WOODMEN HILLS METROPOLITAN DISTRICT  
LIFT STATION #1 REPLACEMENT  
LANDSCAPING PLAN & NOTES

100% DESIGN DRAWINGS

PCD File No. PPR1841

LANDSCAPING

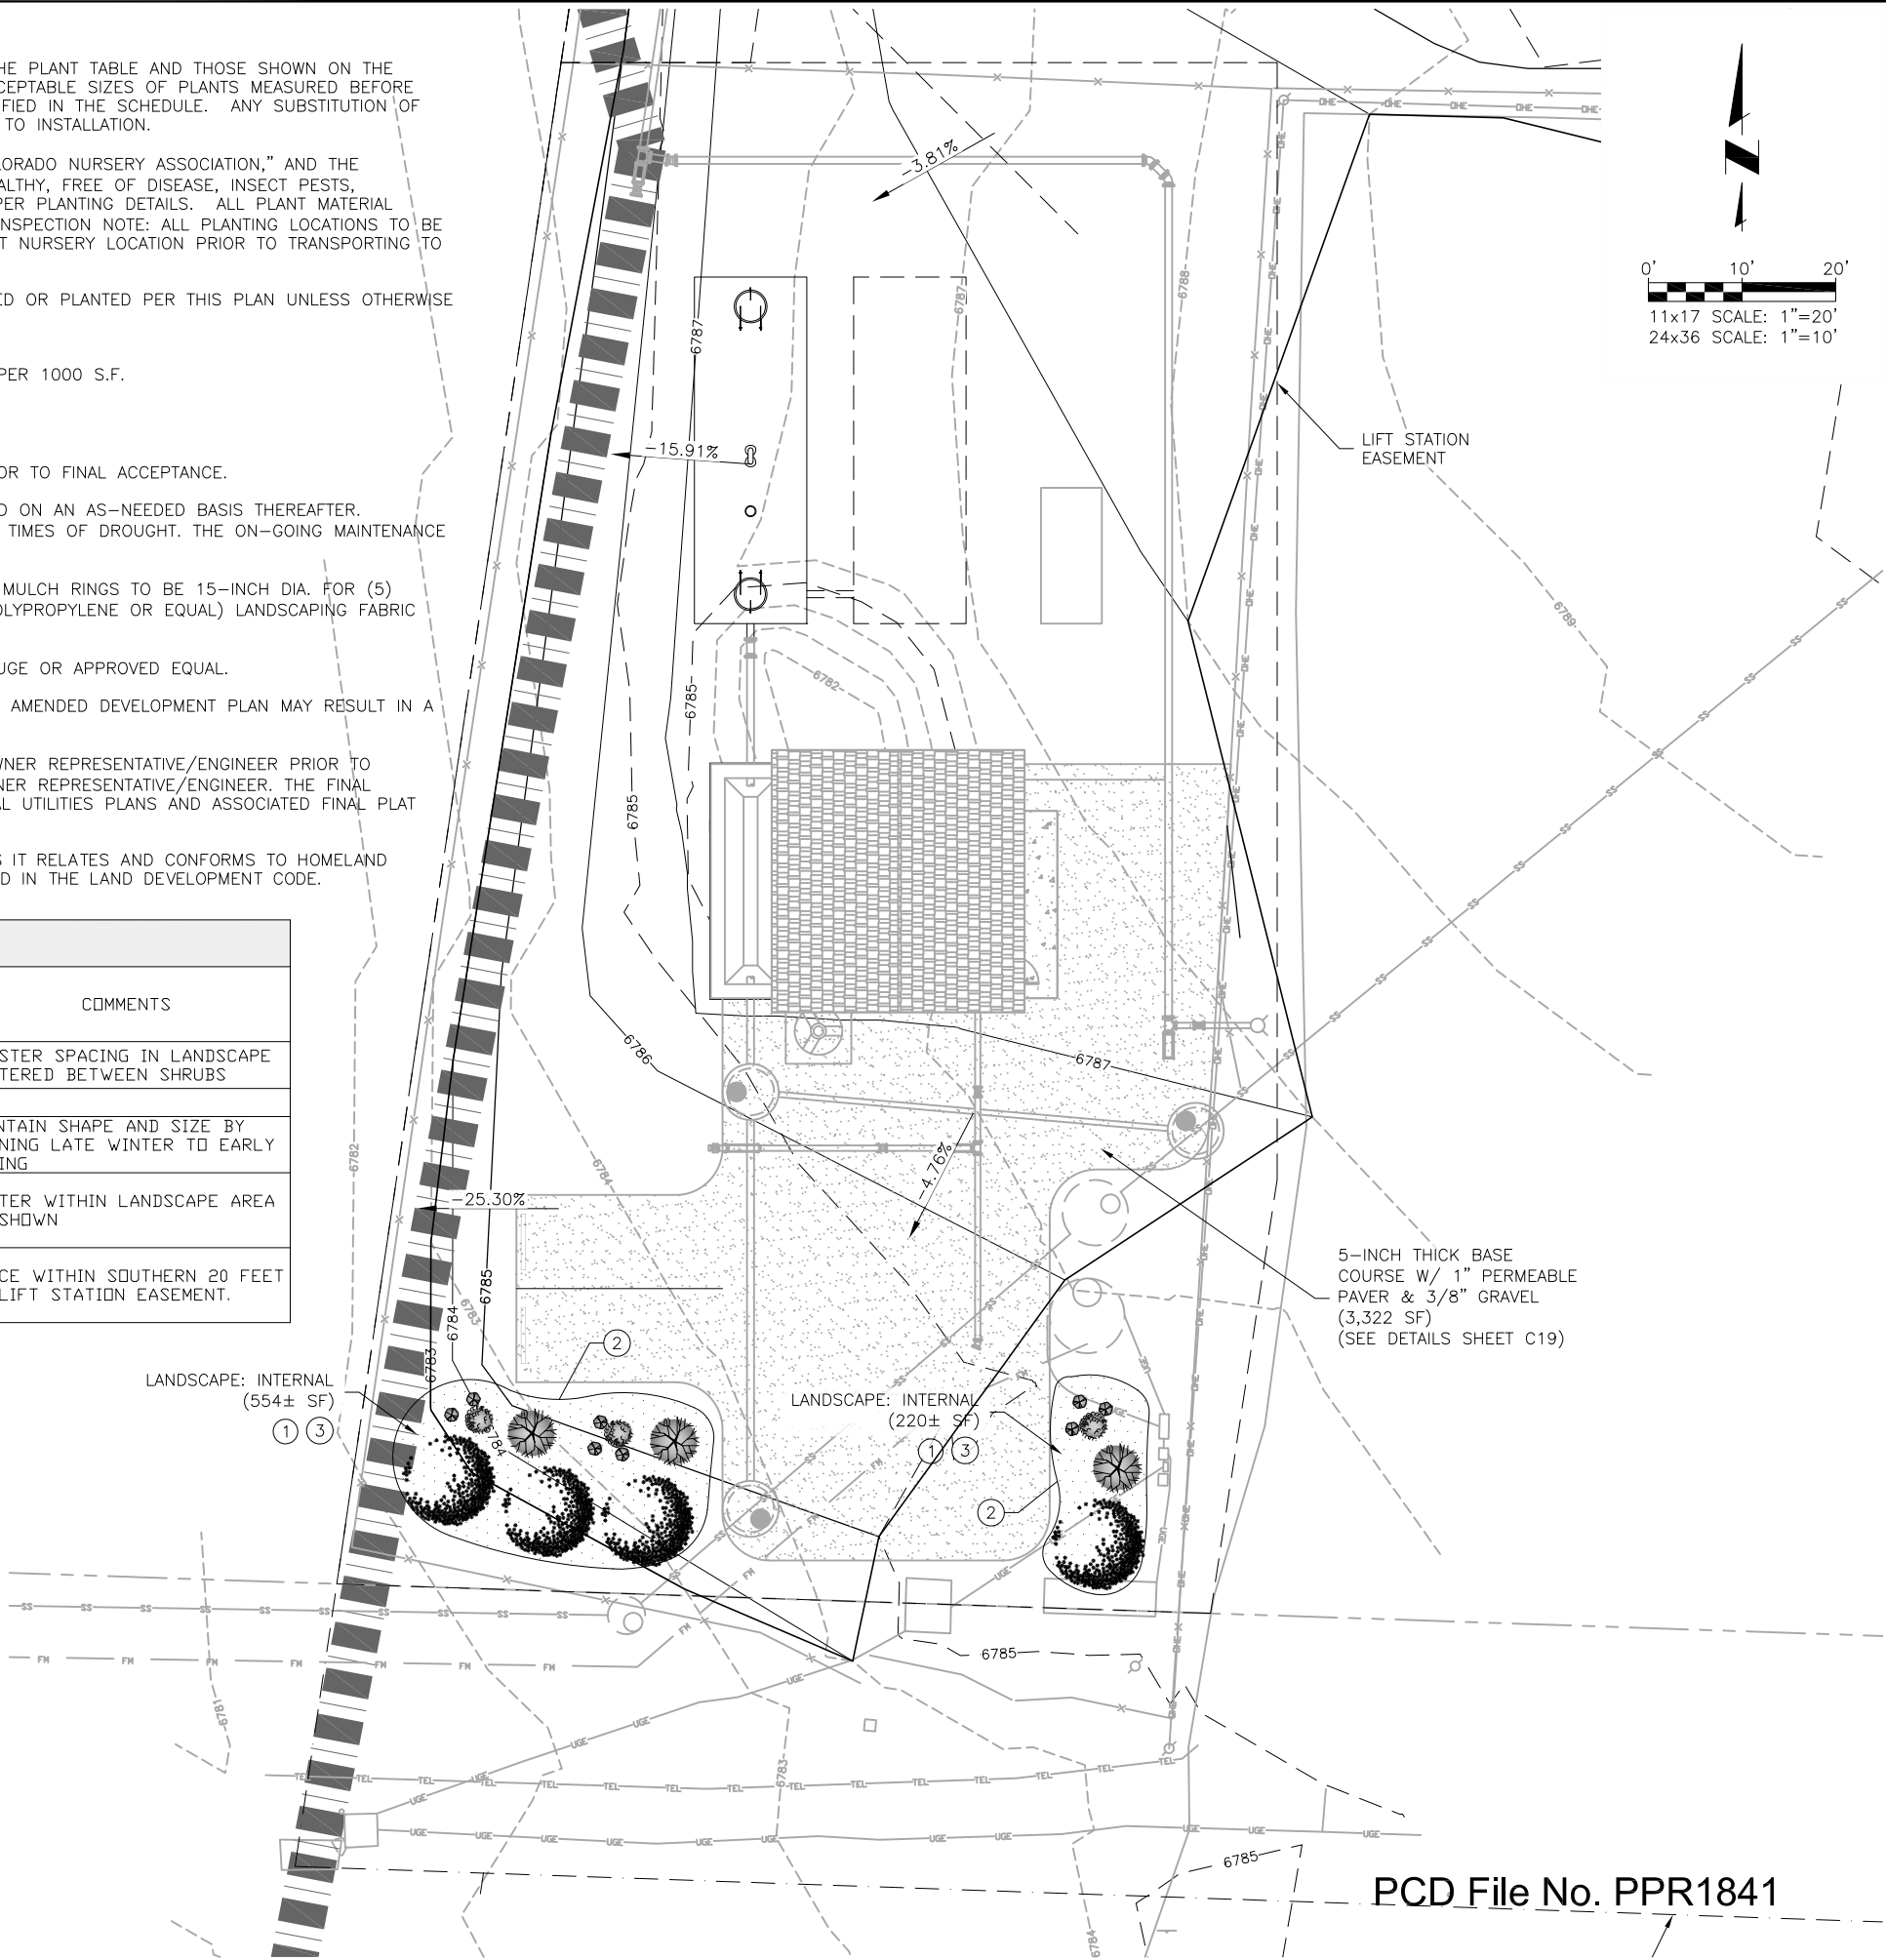
Trees and landscaping required for roadway landscaping as stated in last comment.

Falcon Highway is considered a Minor Arterial and would require roadway landscaping with a 20 foot depth with 1 tree per 25 feet of frontage.
